**Re: PA22-042 – Sunnyside Village Co-Housing – Technical Review 1**  
3121 66<sup>th</sup> Ave NE – APN: 29050300402100

**PRELIMINARY SUBDIVISION / CUP COMMENTS**

B3 COTTAGE C - COLOR ELEVATION - BACK  
1/4" = 1'-0"

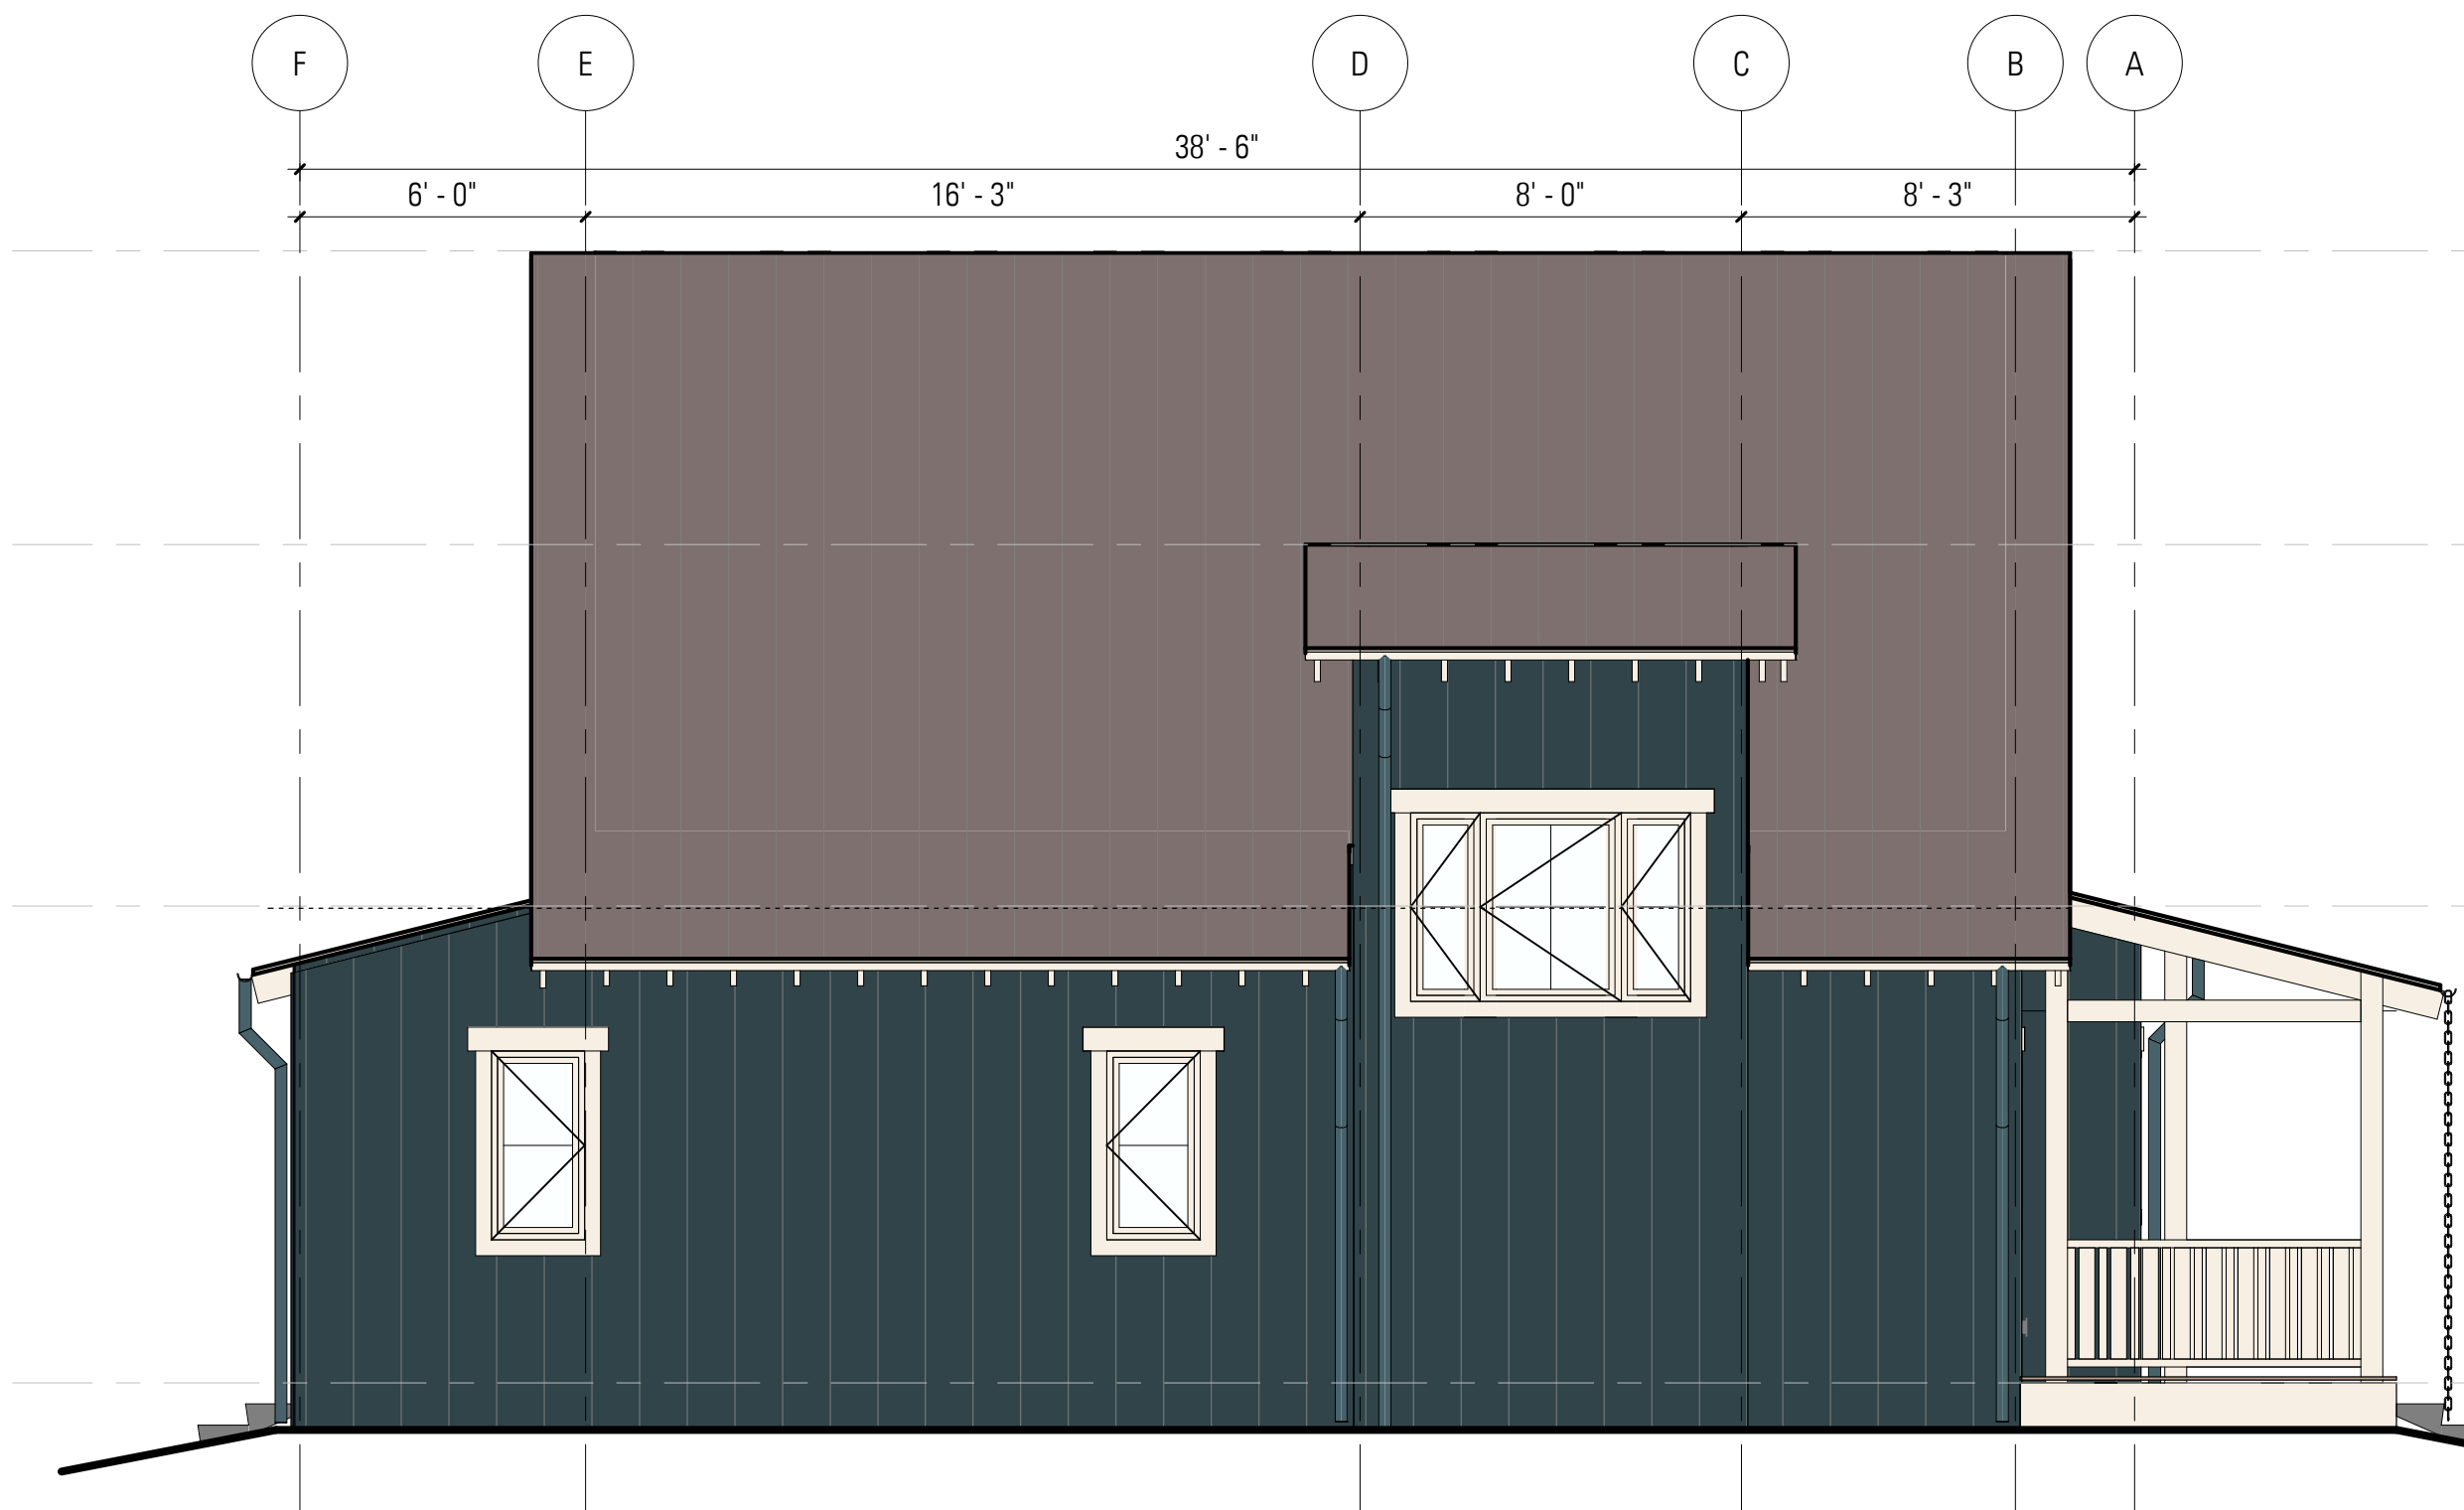
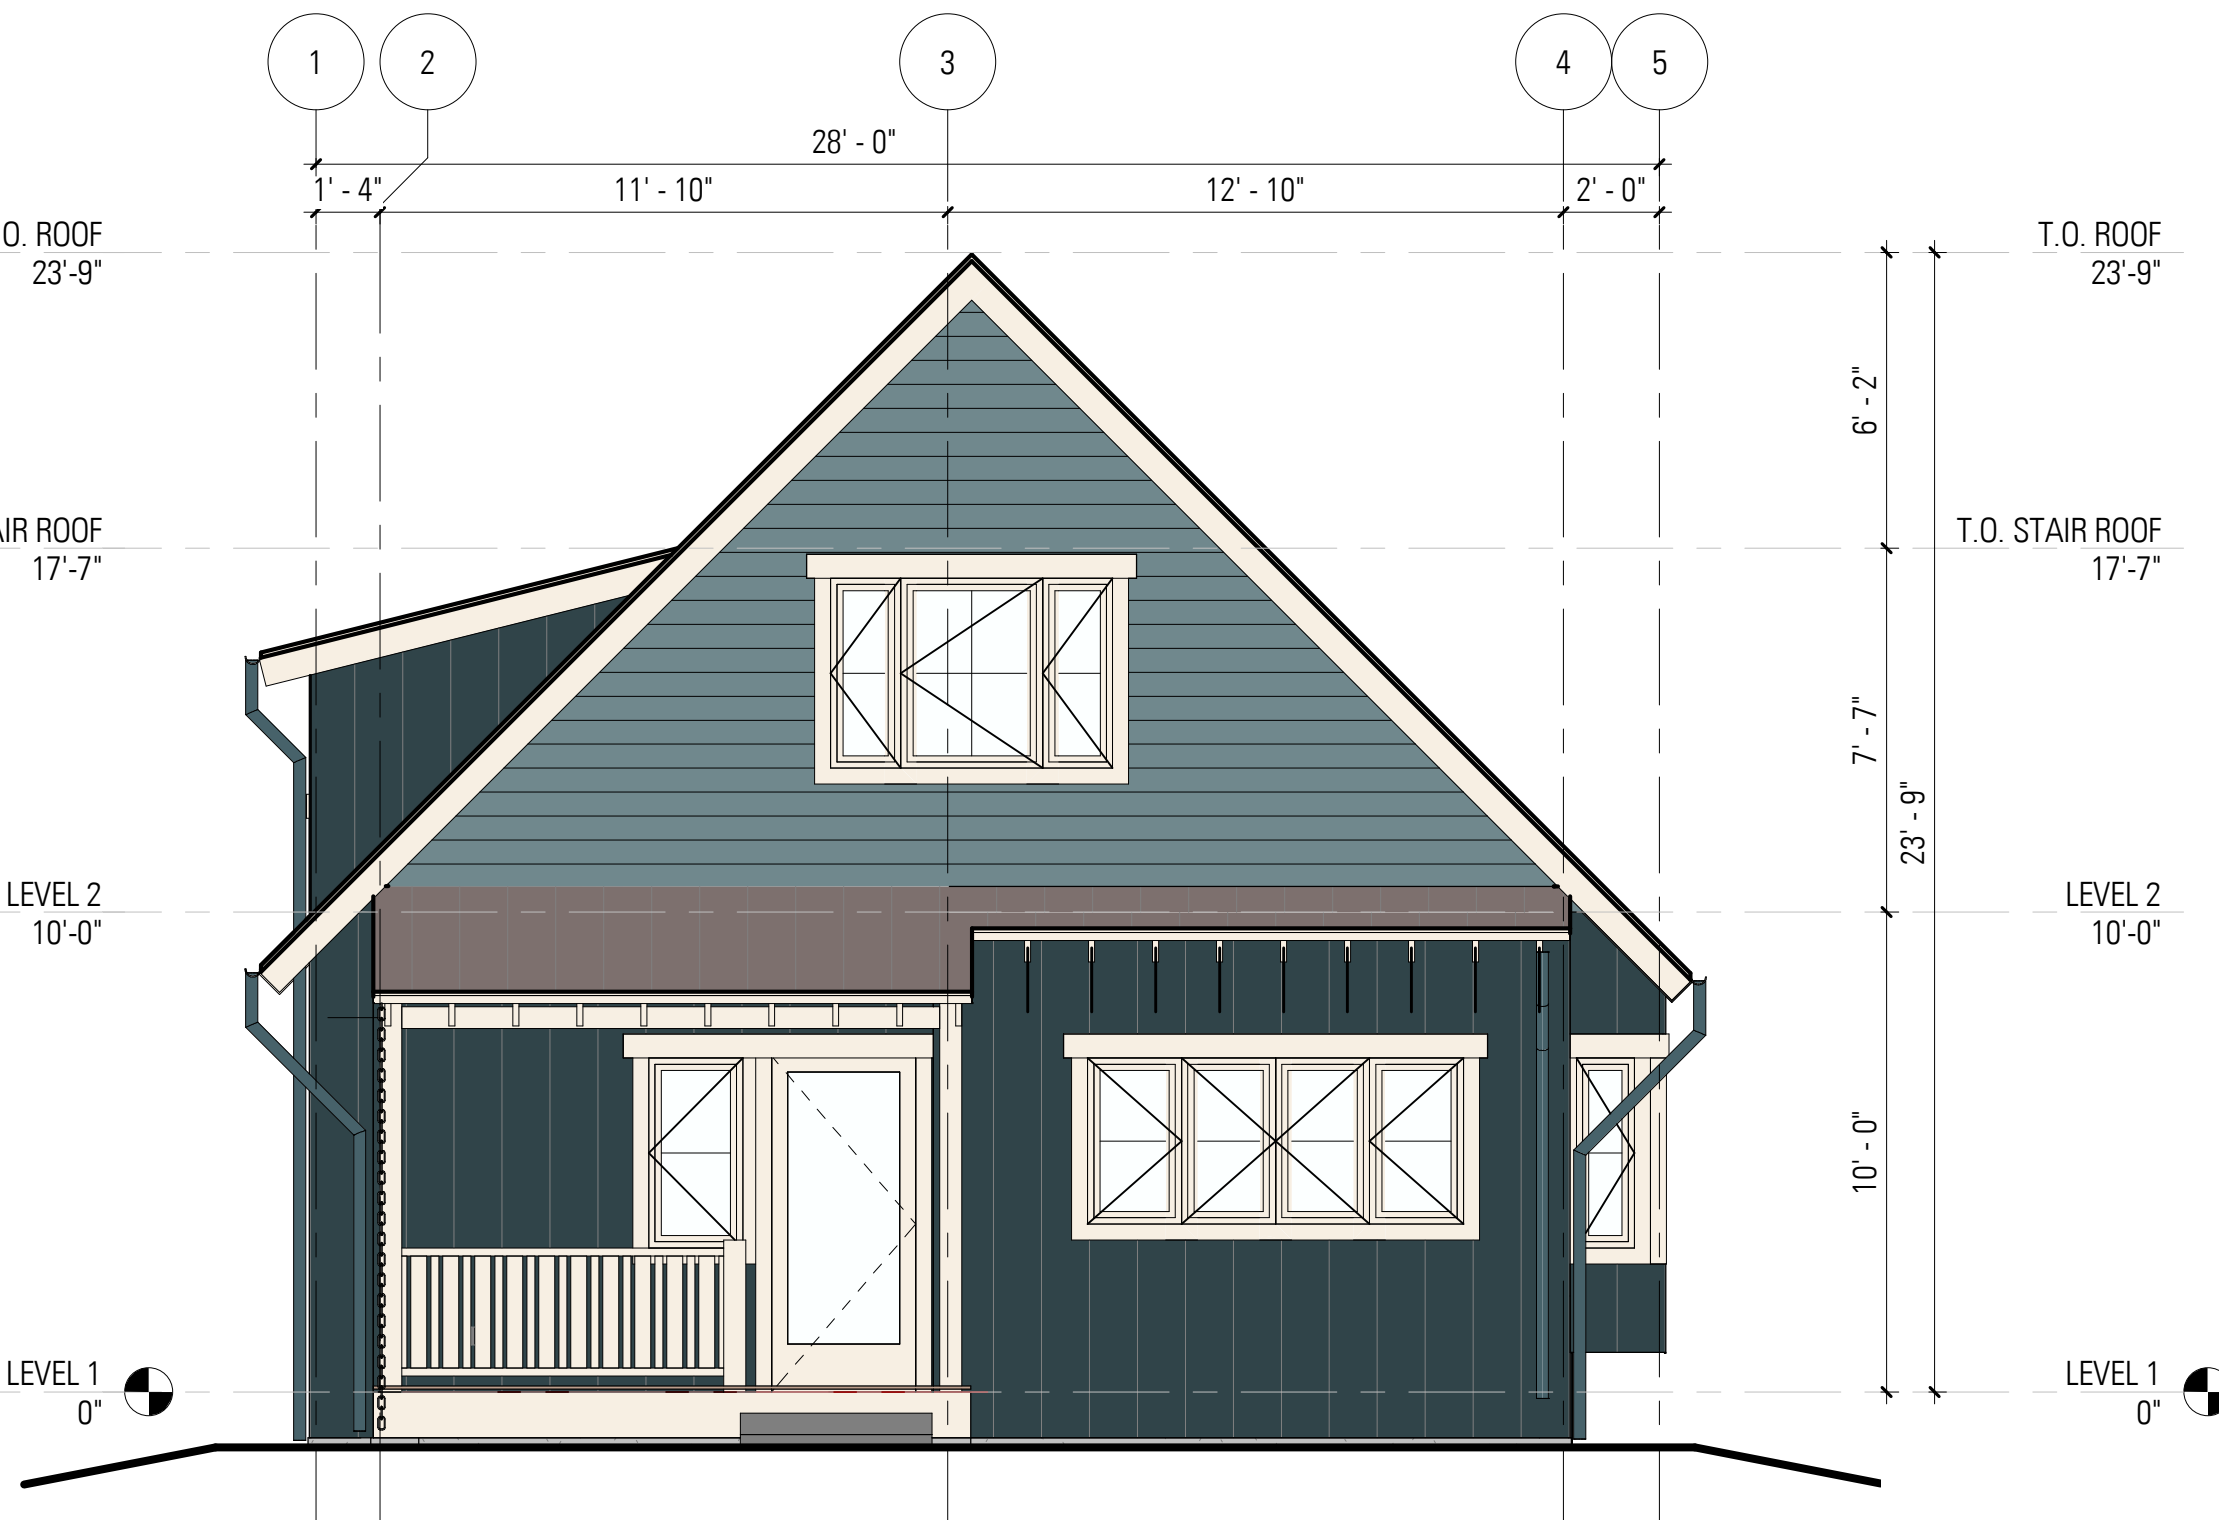
- 9. As proposed, the cottages do not appear to be visually different enough per MMC 22C.010.280(9). Proposed cottage plans A & B and C & D appear to be the same externally, with the exception of color. The cottages must offer a variety of visual interest, such as different roof forms, window design and entries.
